20 August 2021

Response to RtS – Waterloo OSD Southern Precinct – SSD 10439

Attachment A – Response to RtS

Sheet title
ELEVATION - NORTH

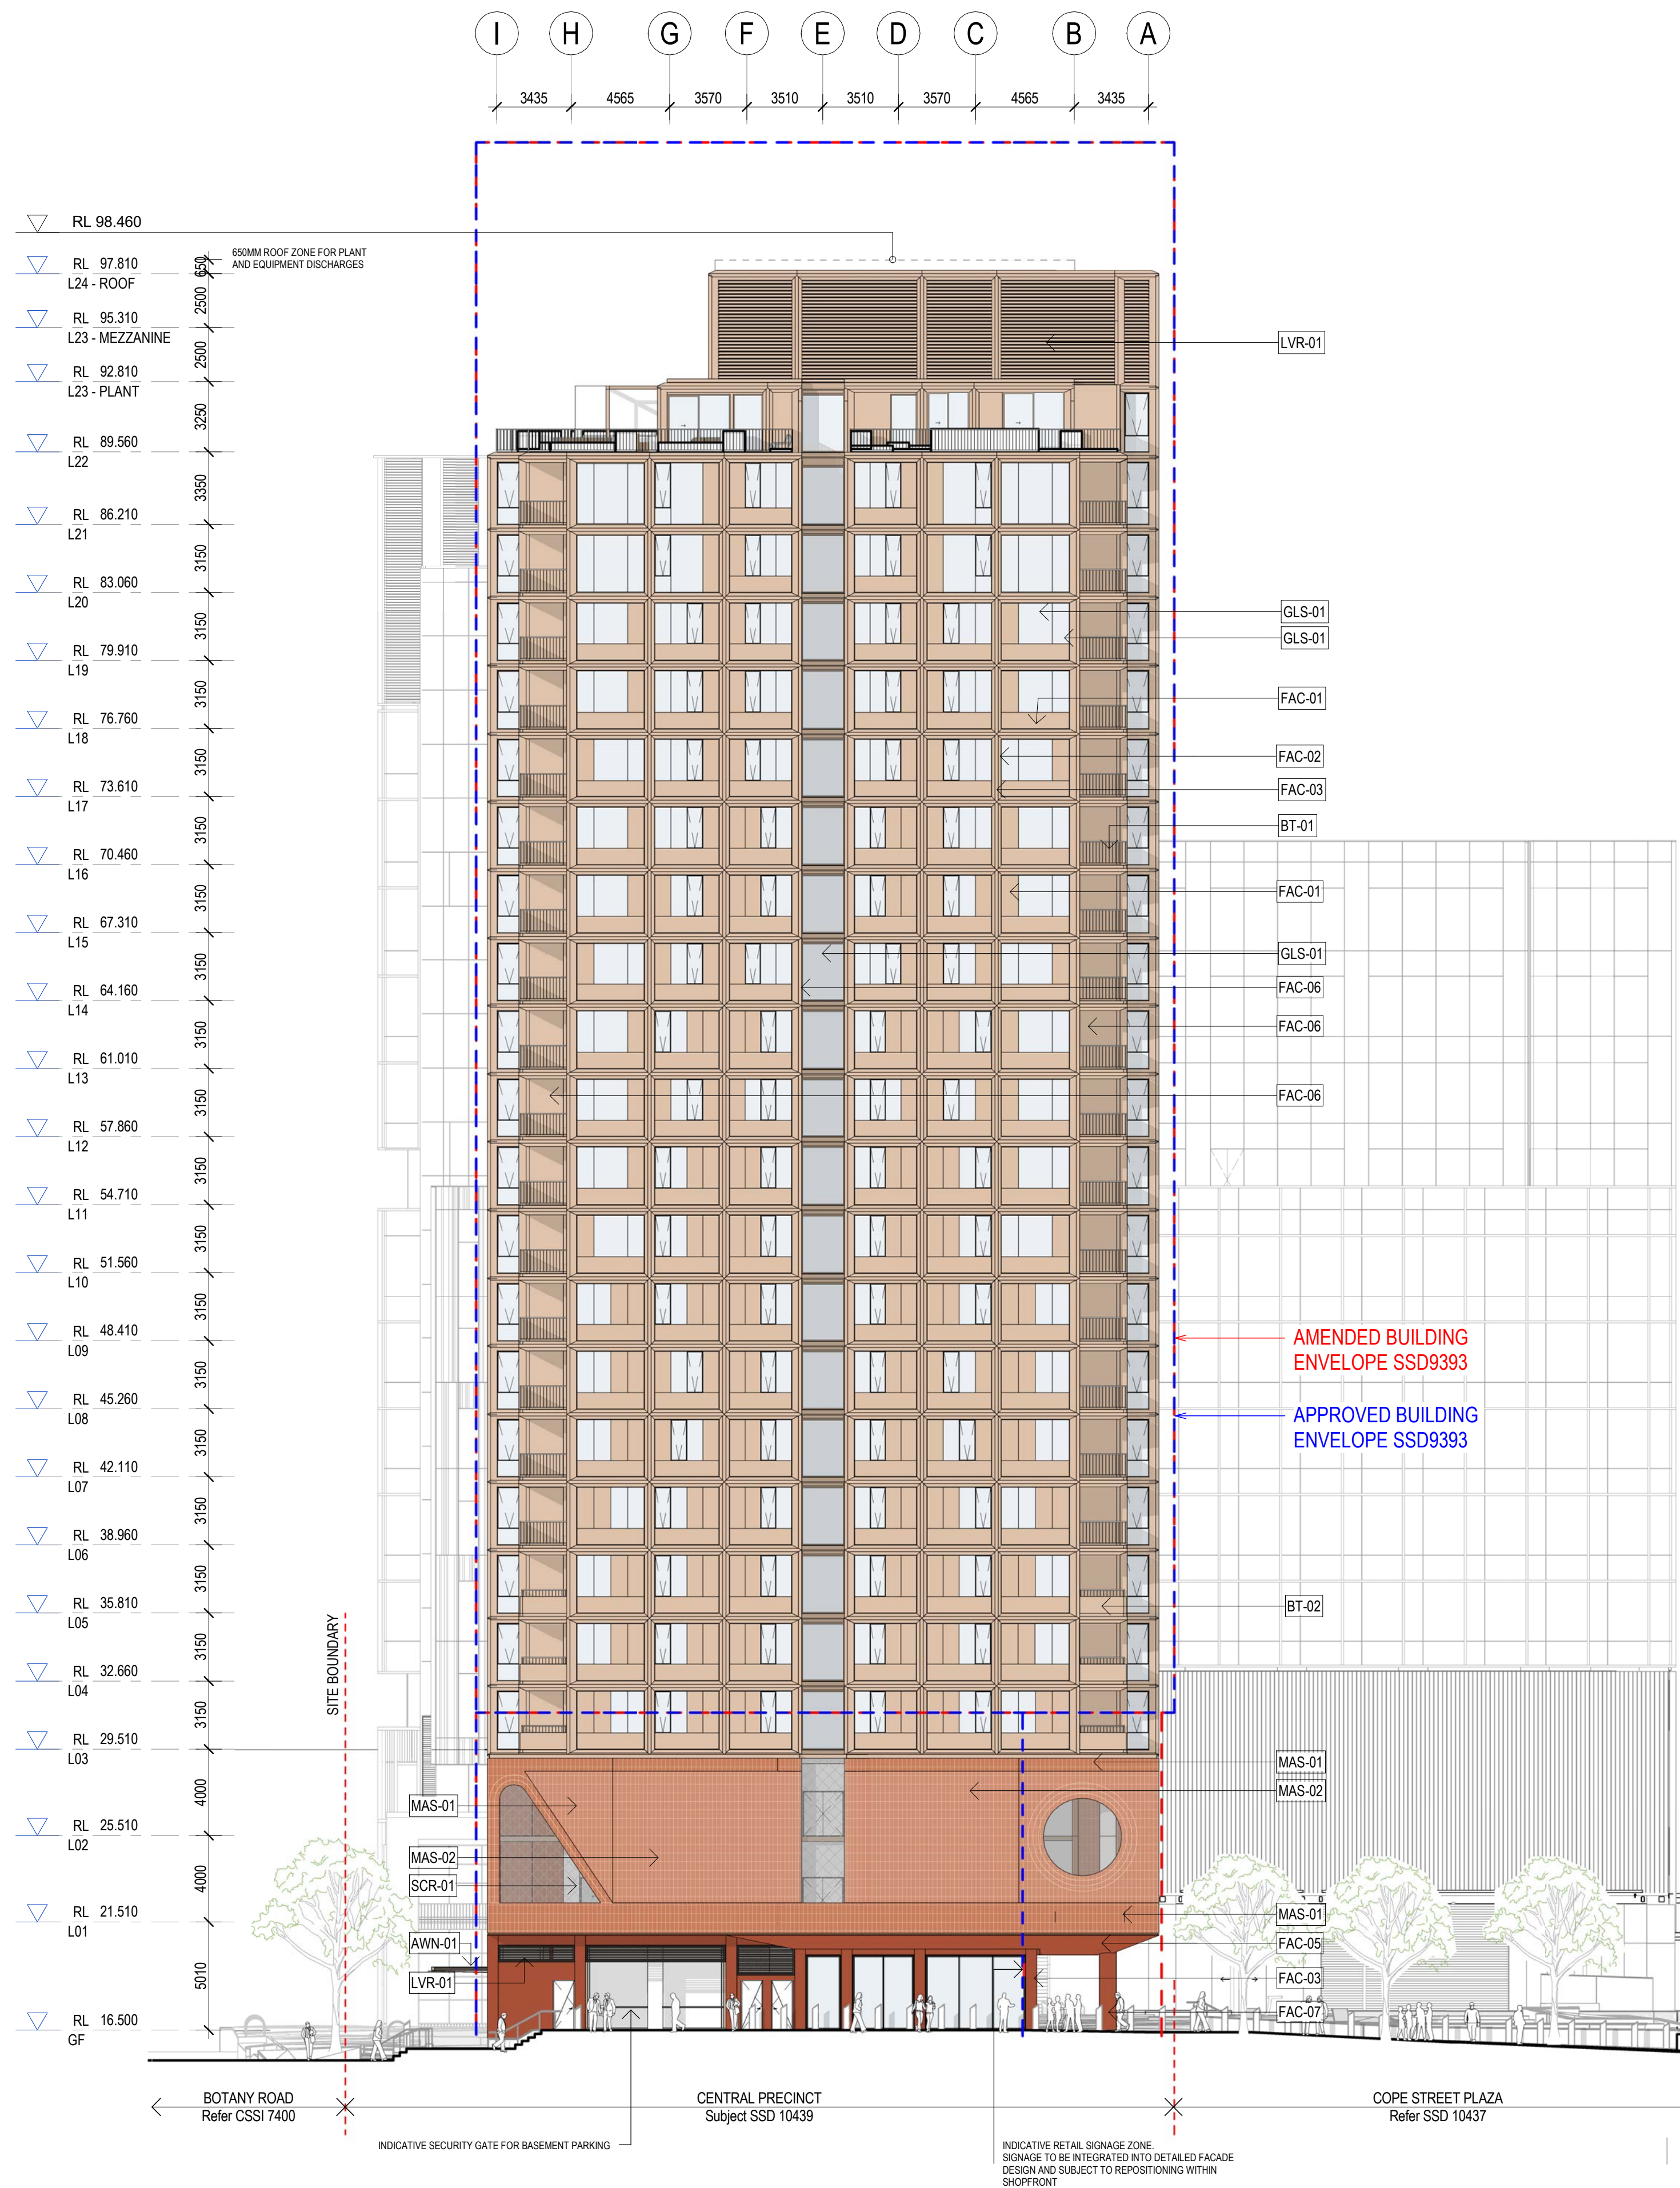
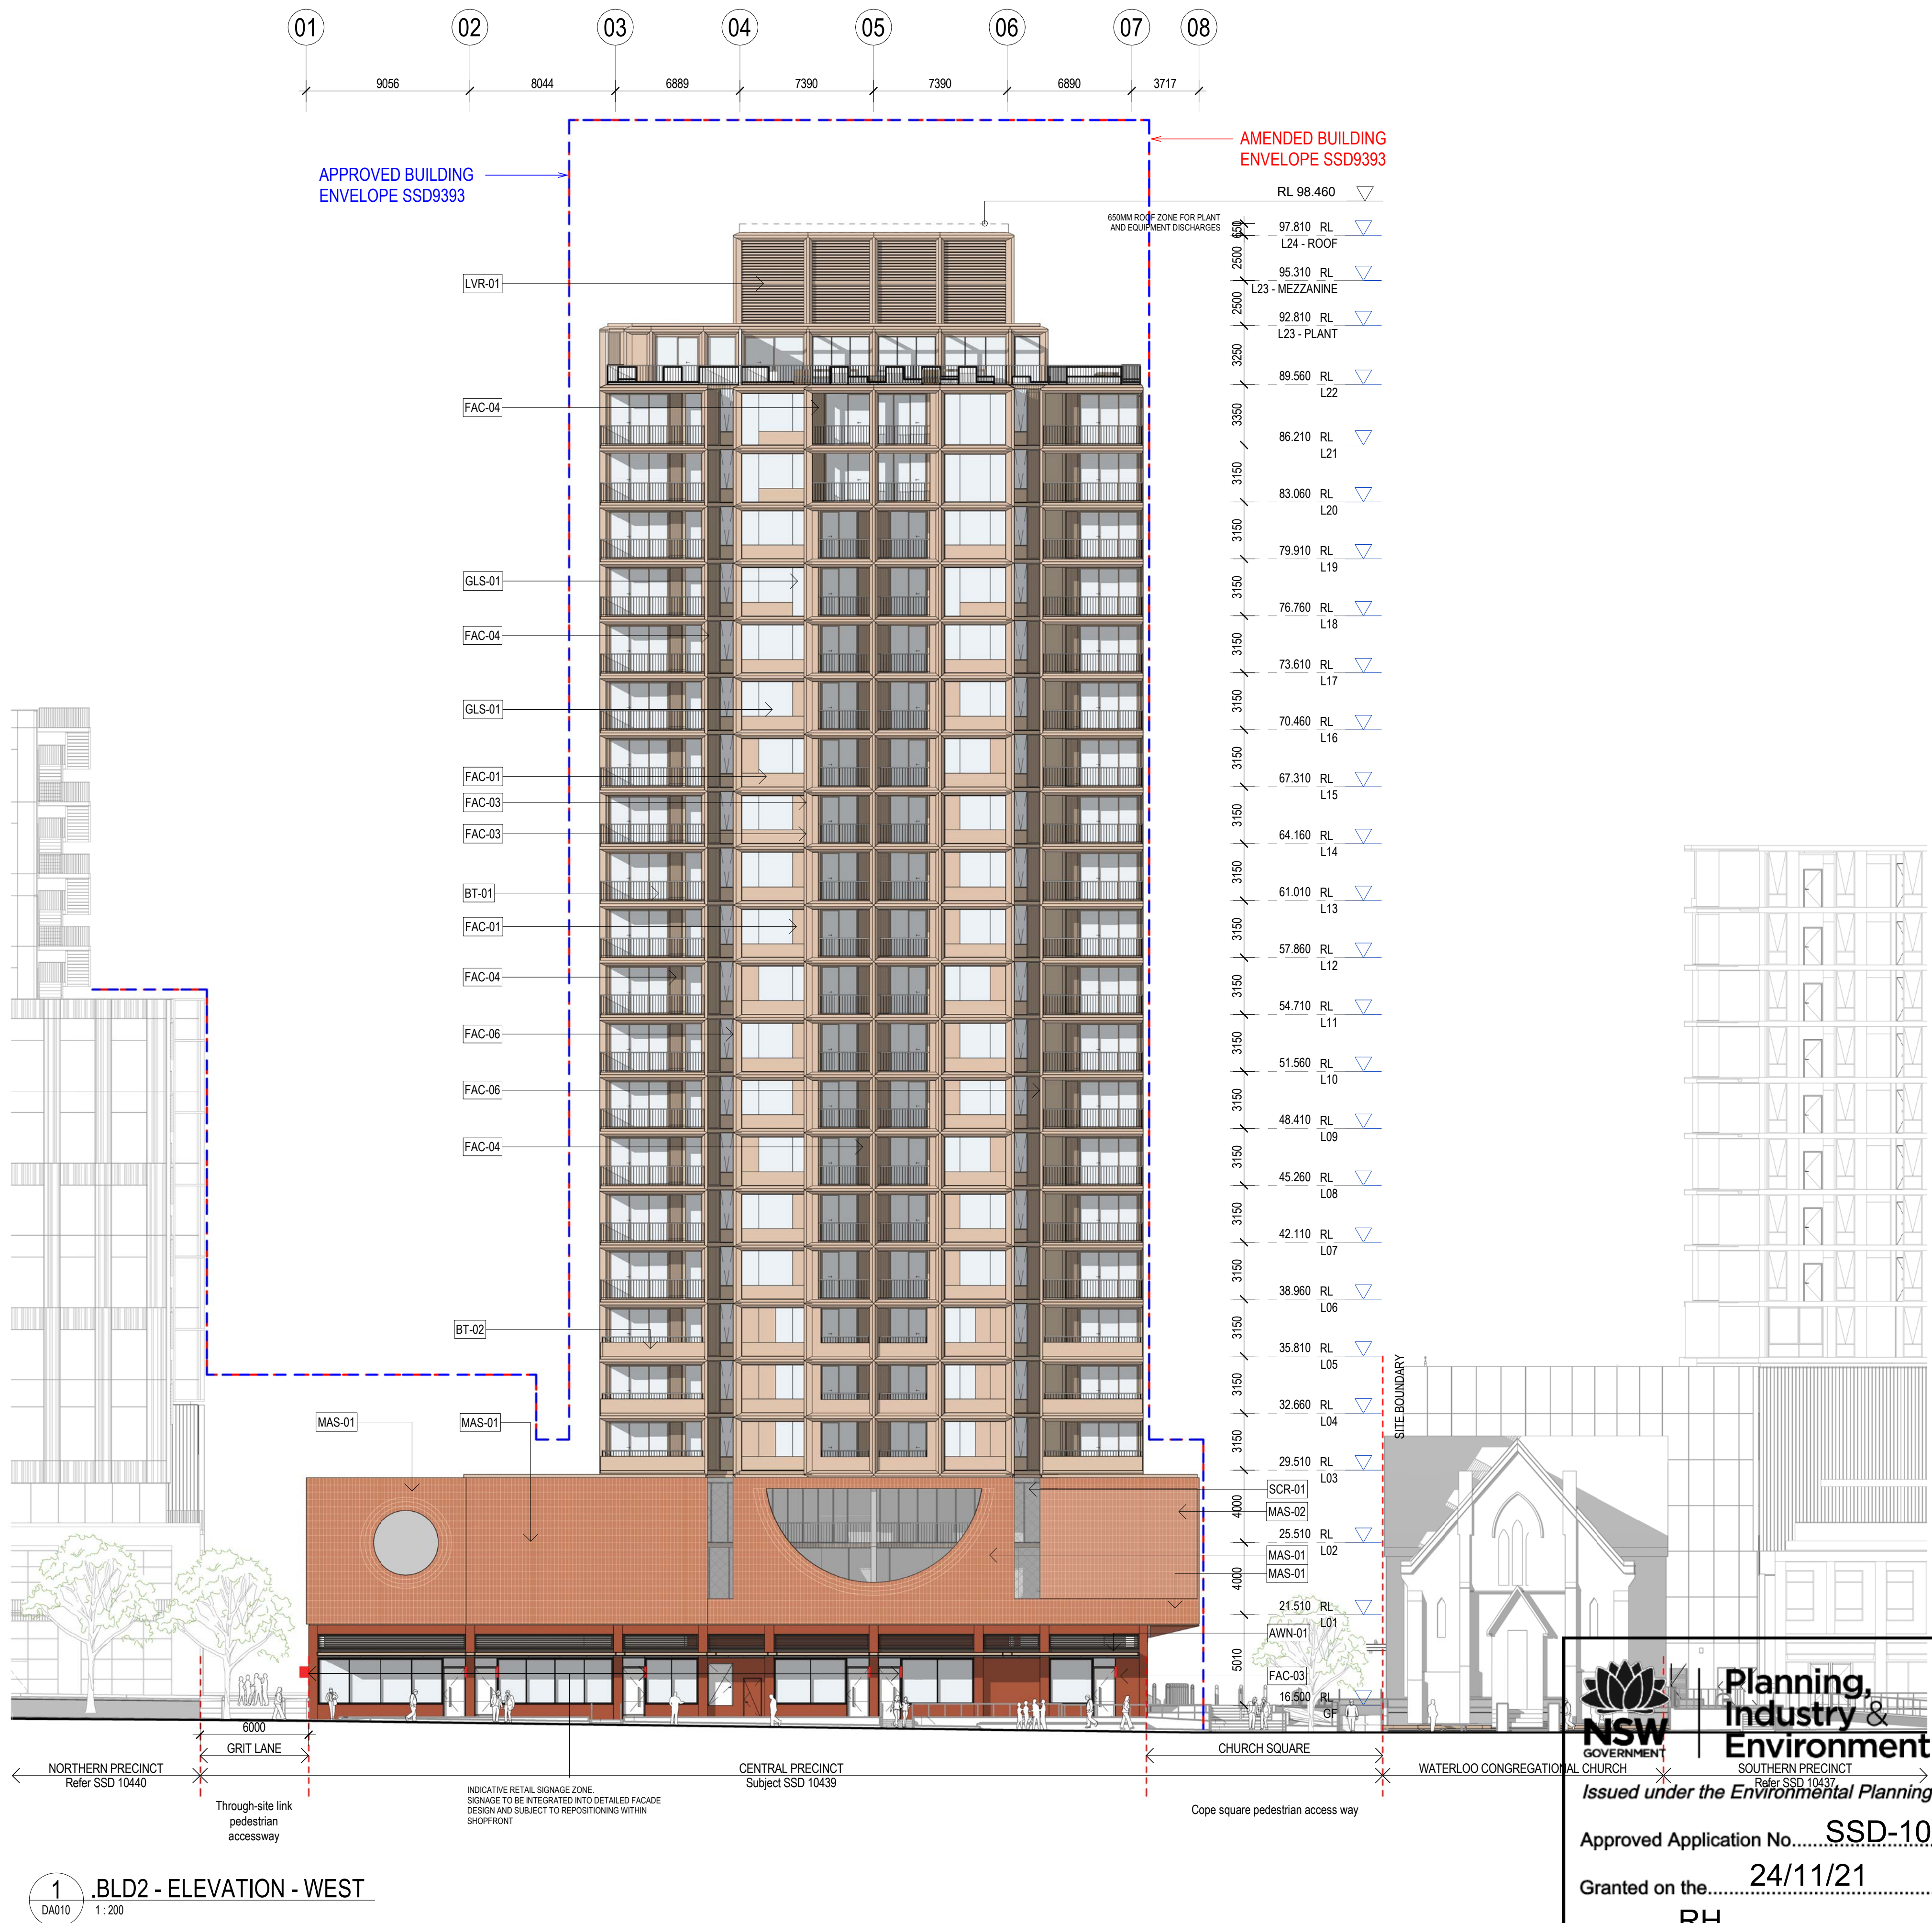
15. A minimum parapet height of 1.2 metres should be provided above RL92.81 to shield proposed plant and equipment, and provide a strong architectural detail to the top of the building.
16. Awning windows provide substandard amenity for occupants by minimising airflow. It is recommended that sashes or casement windows be provided instead.
